DRB Application No.: 08DRB-70135	Project # 1004727
Project Name: LANDS OF BACA AND CHAVEZ	
Agent: GARCIA/KRAEMER & ASSOC.	Phone No.: 242-5566

8. **Project# 1004727**
08DRB-70135 MINOR - PRELIMINARY/
FINAL PLAT APPROVAL
- GARCIA/KRAEMER & ASSOC. agent(s) for ELADIO F & ETNA L CHAVEZ request(s) the above action(s) for all or a portion of Lot(s) 2, Tract(s) 84B, **LANDS OF BACA AND CHAVEZ**, zoned RA-2, located on GRIEGOS NW BETWEEN SAN ISIDRO AND RIO GRANDE containing approximately 0.7791 acre(s). (F-13) **THE PRELIMINARY PLAT WAS APPROVED WITH FINAL SIGN OFF DELEGATED TO TRANSPORTATION FOR VERIFICATION OF ADEQUATE RIGHT-OF-WAY, INDICATION OF WALL, AGIS DXF AND A COPY OF THE RECORDED PLAT.**

RE: Tract 84B & Lot 2, Lands of Baca and Chavez

PLAT
OF
LOTS 2-A & 2-B
LANDS OF BACA & CHAVEZ
(BEING A REPLAT OF LOT 2 AND TRACT 84B M.R.G.C.D. MAP 31)
SECTION 31, TOWNSHIP 11 NORTH, RANGE 3 EAST, N.M.P.M.
CITY OF ALBUQUERQUE, BERNALILLO COUNTY, NEW MEXICO
JANUARY 2008

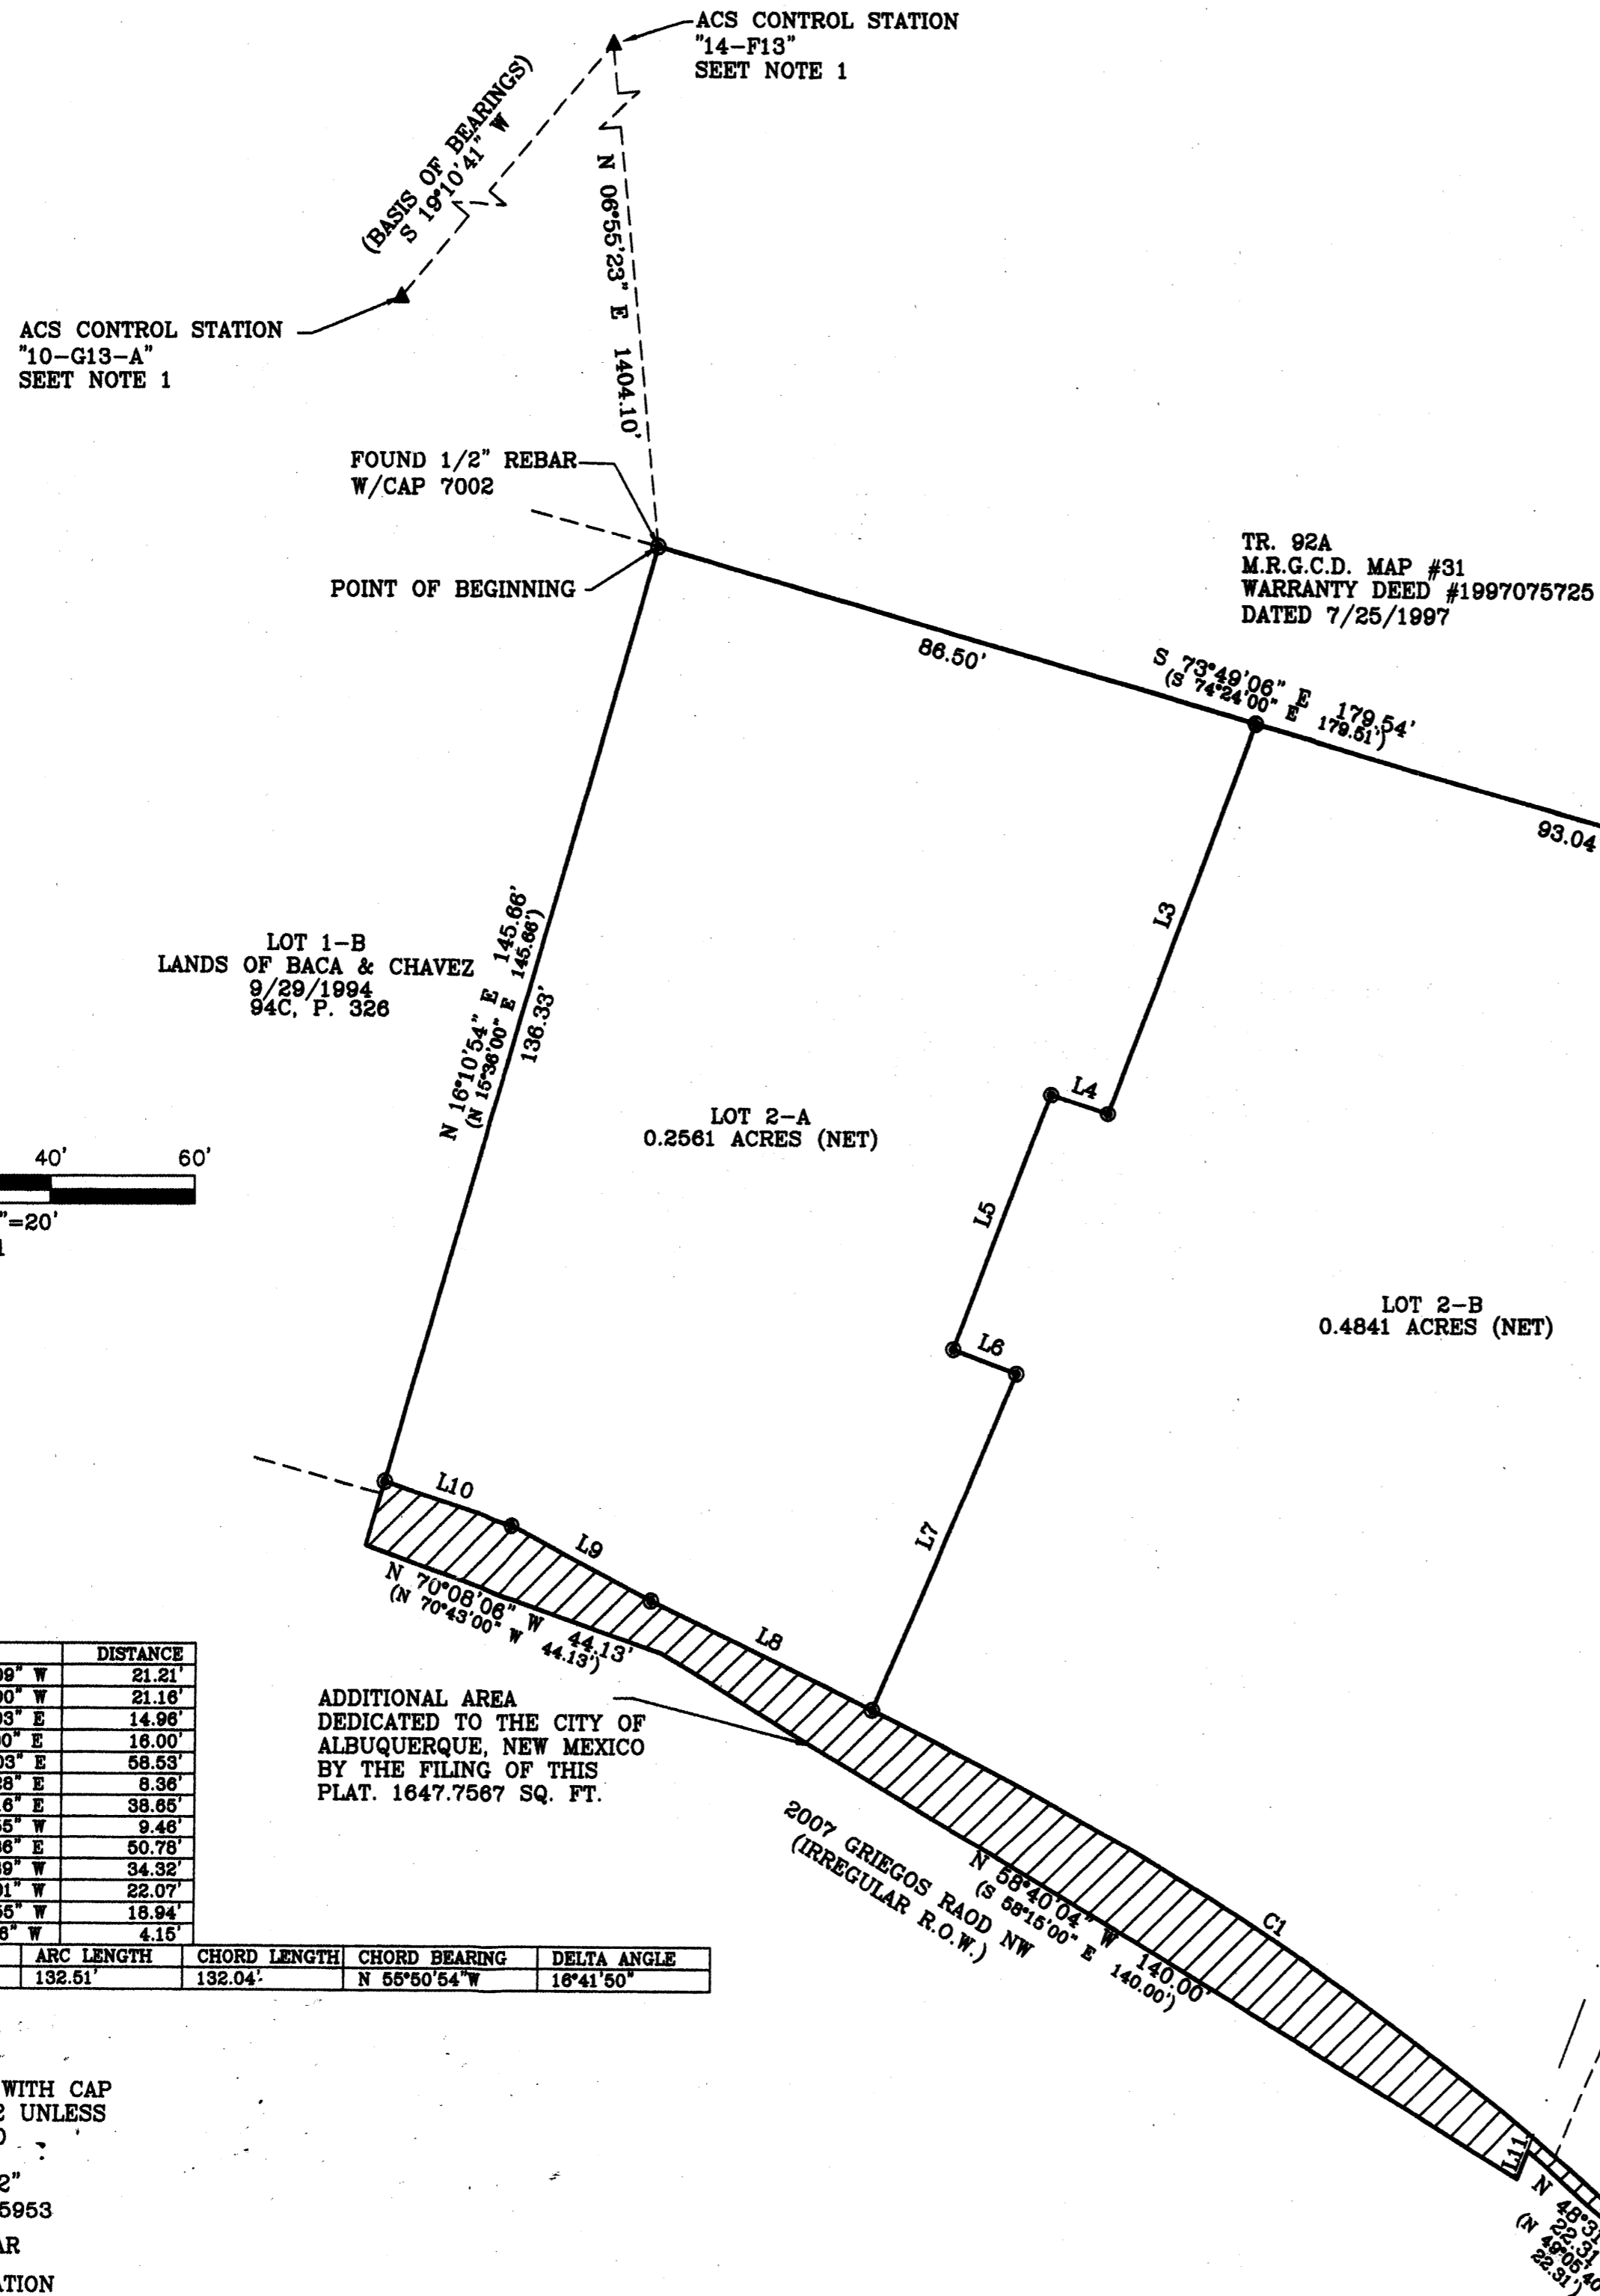
TRANSPORTATION: - verify adequate R-O-W per comments

MRGCD must sign plat.

For future reference, please revise solar note to be specific to this type of request, i.e. use the words "THIS PLAT" and not "REQUESTED FINAL ACTION" and do not use the words "OR SITE DEVELOPMENT PLAN FOR SUBDIVISION" at the end of the note.
